From: PAUL REED [REDACTED]
Sent: 27 May 2021 09:28
To: Planning.Responses; Nicola Moore
Subject: Re: Request for further information M/75/21/NMA
Attachments: 301 Rev D Proposed Updated North and South Elevations.pdf; 302 Rev F Proposed Updated East and West Elevations.pdf

*Non material amendment following grant of M/83/20/PL for the front elevation upper floor windows (**W1-03 & W1-04**) adjusted in height and gym annexe roof reduced by 316mm; ground floor door (DG-04) has glass panel; ground floor window to gym annexe WC & house plant room removed; glazing bars design changed on some windows throughout but no size change; chimney on front & rear elevations 15cm wider, on side elevations chimney is 15cm narrower, height remains the same; all timber & slate vertical cladding replaced by stone cladding and garden wall - cut back, curved section removed*

PROPOSED EAST AND
WEST ELEVATIONS & SITE
SECTION

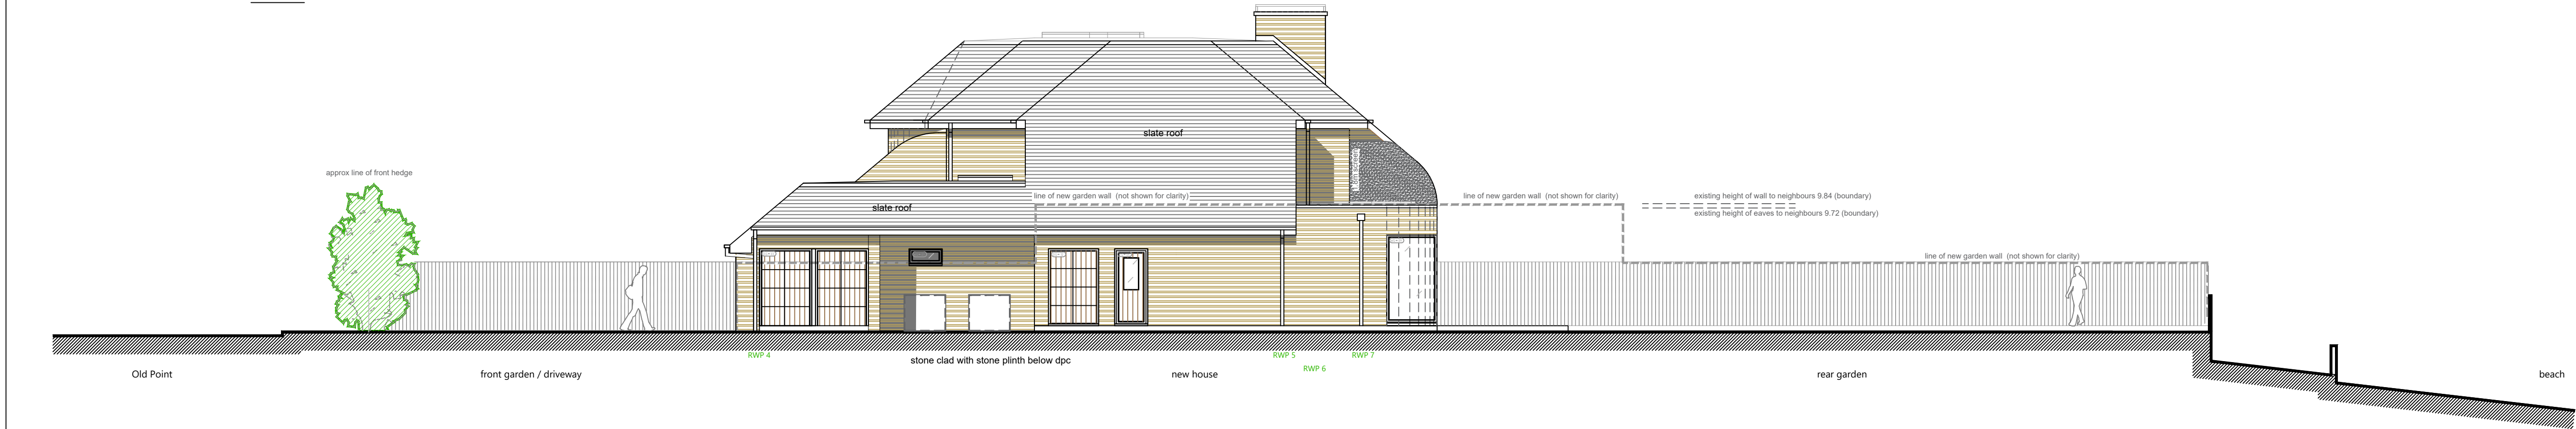
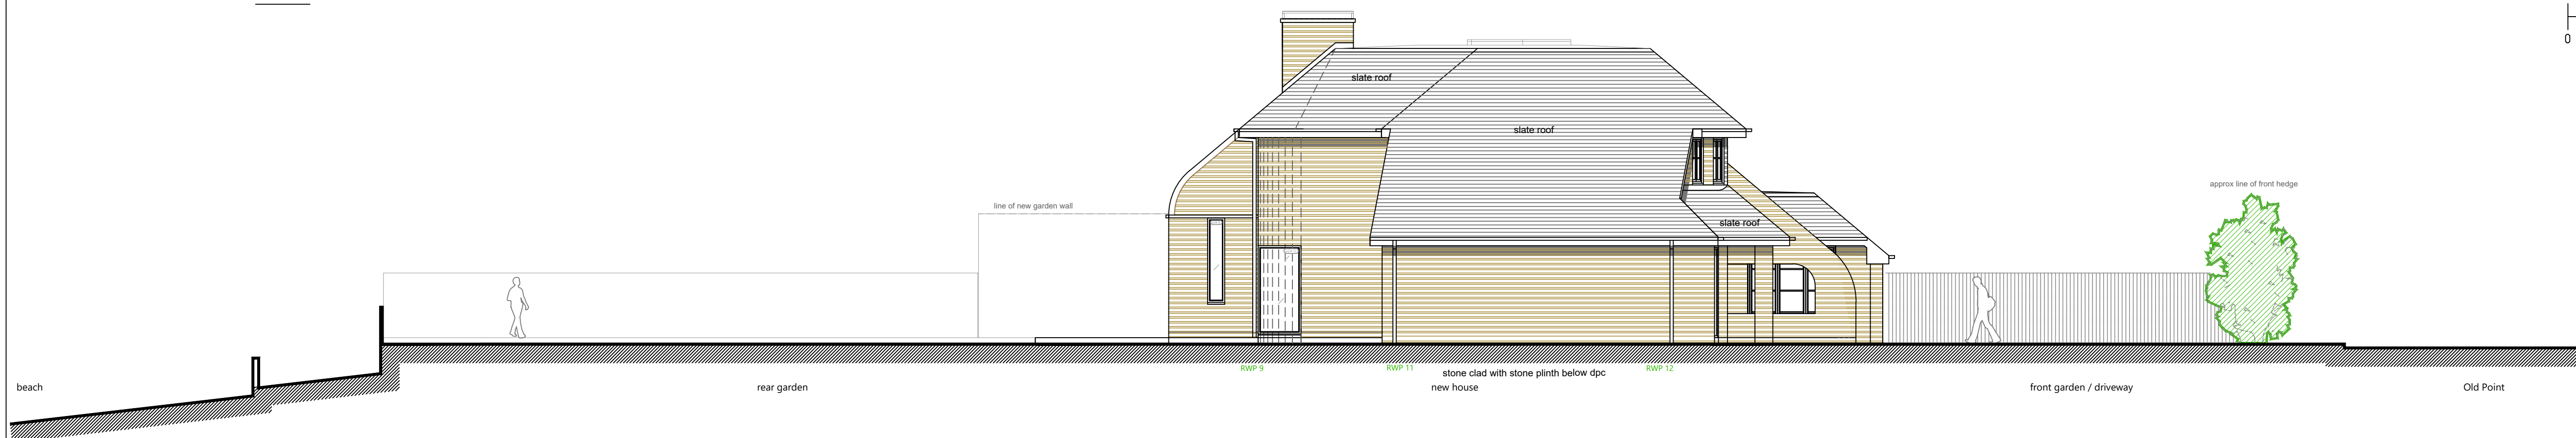
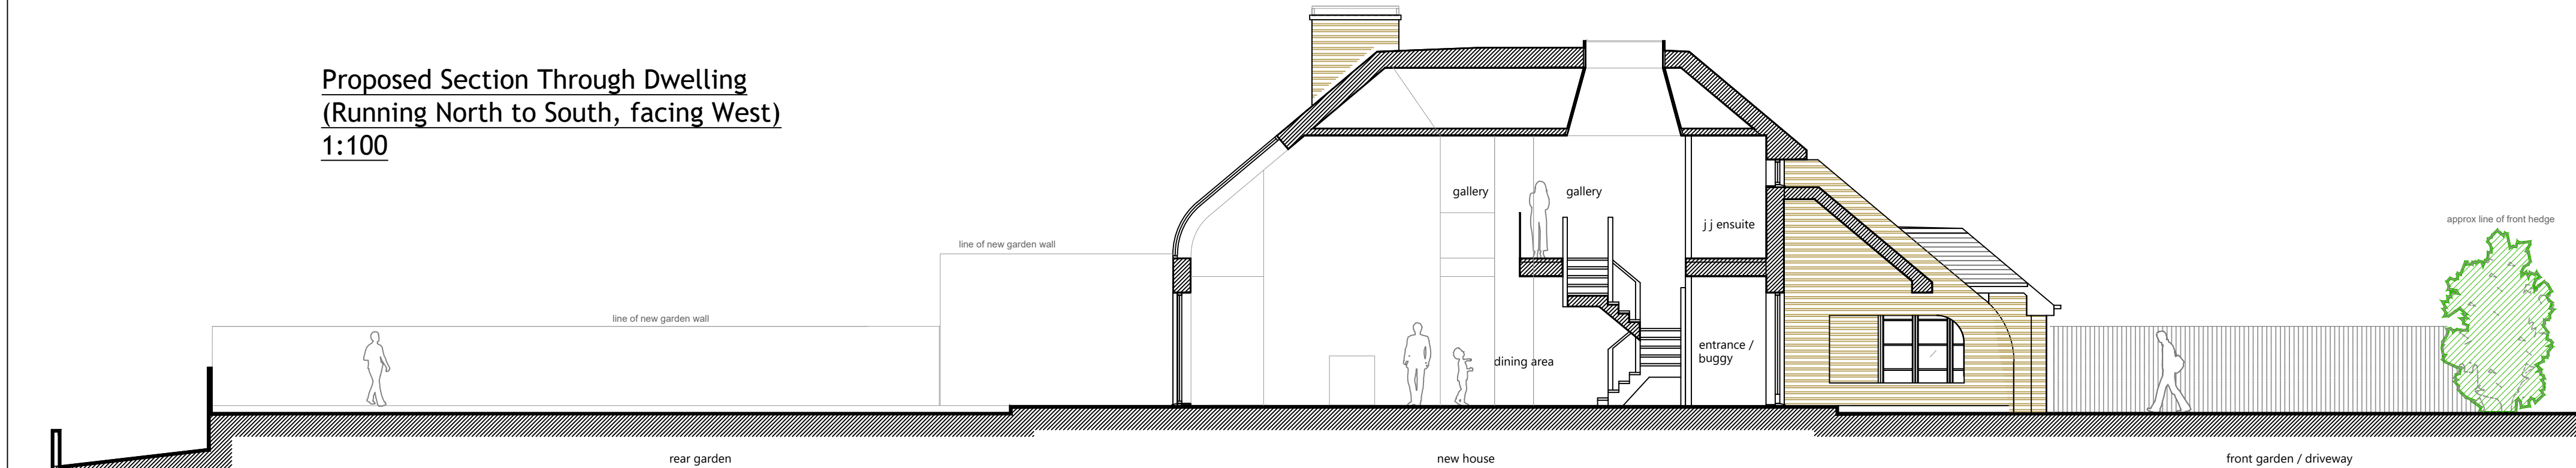
Thanks, it has highlighted something I needed to adjust re a window reference, see attached revisions to the drawings, the windows referenced should be W1-03 and W1-04.

attached updated drawings to match this to substitute previous ones
